CITY OF ALBUQUERQUE

July 11, 2017

**RE: Lead Ave. SW Condominiums
Grading Plan
Stamp Date: 7/10/17
Hydrology File: K13D075**

Based upon the information provided in your re-submittal received 7/7/2017, the Grading Plan is approved for Building Permit.

SHEET CI-1

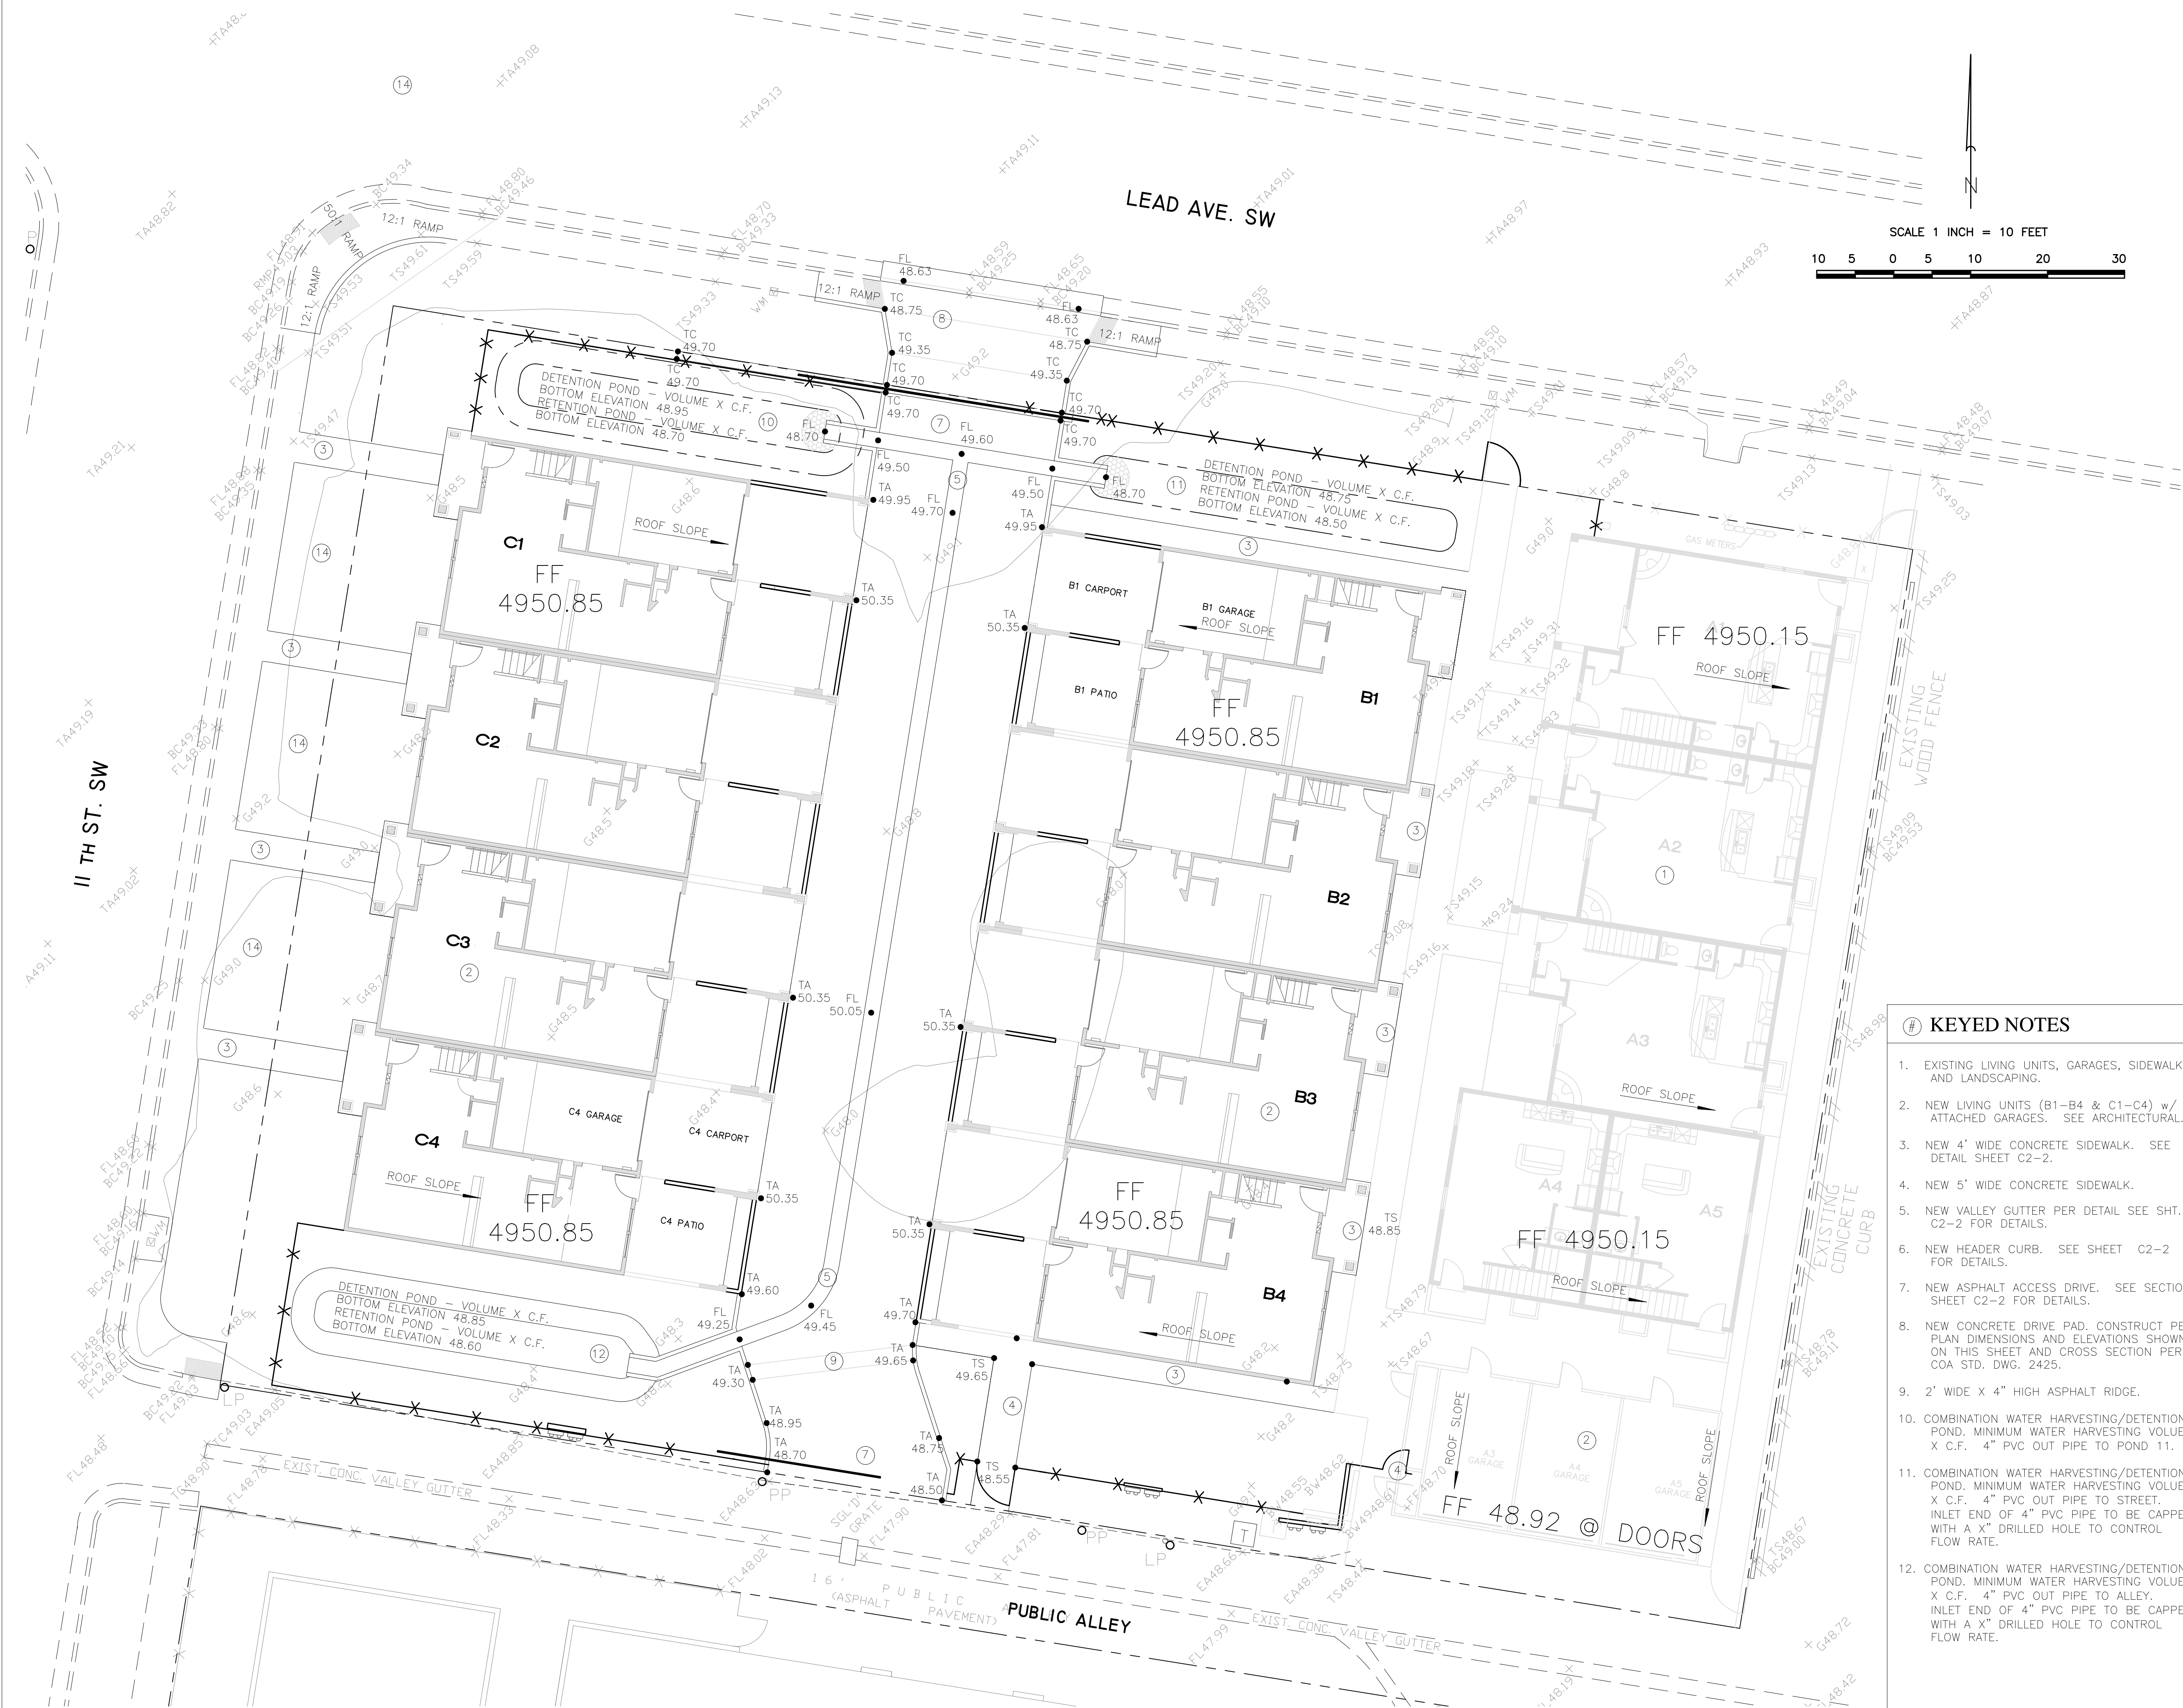
1. The Vicinity Map and the FEMA FIRM map have been added to sheet C1-1
2. The Keyed Notes are completely rewritten.
3. The Keyed Notes are completely rewritten.
4. The drainage data is shown on C1-2.
5. Since the existing conditions have no impact on the project on the design it is requested that the calculations be accepted as they are. Basin A discharges to the alley.
6. See response on comment 4.
7. Arrows have been added.
8. Front yard ponds are noted on sheet C1-1.
9. It is located at the south end of Basin B.
10. This was a previous drainage scheme designed in 2014 for a different site plan for the same site..
